Your ref:
Our ref: 20/02047/F
Please ask for: Mrs Lesley Raby
Direct dial: 01553 616818
Direct fax: 01553 616652
E-mail: borough.planning@west-norfolk.gov.uk

17 December 2020

Details: **Replacement of deteriorating timber framed asbestos garage/workshop with timber cabin/studio on existing concrete foundation. at Cuckstool Cottage Cuckstool Lane Castle Acre Norfolk PE32 2AH**

PLAN VIEW

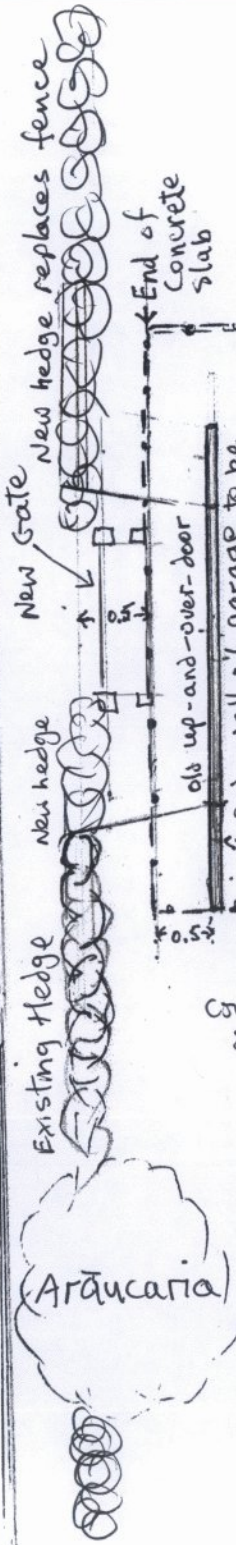
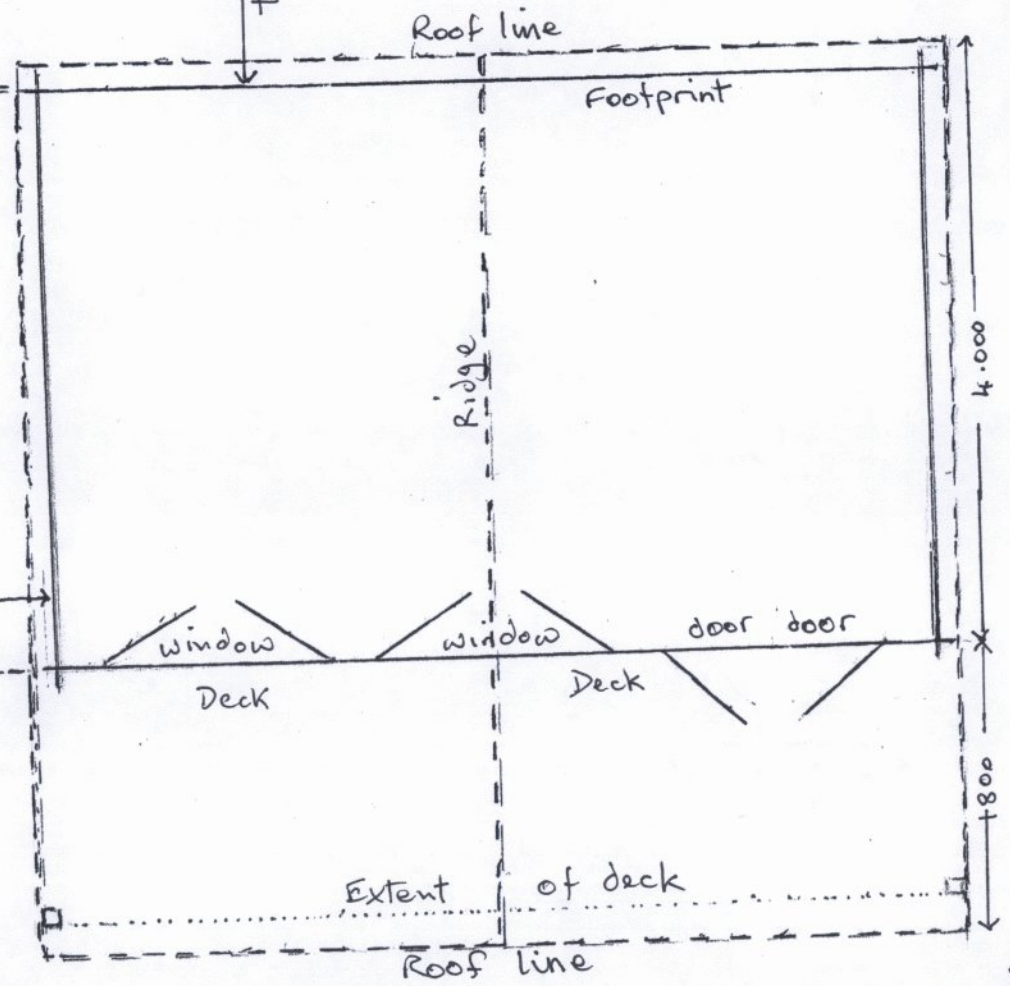
1. As the property lies within an area at risk to flooding, please complete the simplified Matrix and return it. The Matrix can be found at https://www.west-norfolk.gov.uk/info/20173/information_for_planning_agents/231/flood_risk_information
2. Please confirm, in writing, that finished floor levels will match existing finished floor levels.
3. In accordance with the National Validation Checklist, which became mandatory on 6 May 2008, we will require information regarding site levels. If site levels are to change, please provide four copies of a site survey drawing, alternatively, if site levels are to remain unchanged, this can be annotated on the relevant plan or advised in writing.
4. The plans submitted are not to the scales shown on the plan. Please submit the full plans again at the correct scales and include a roof plan of the new building.
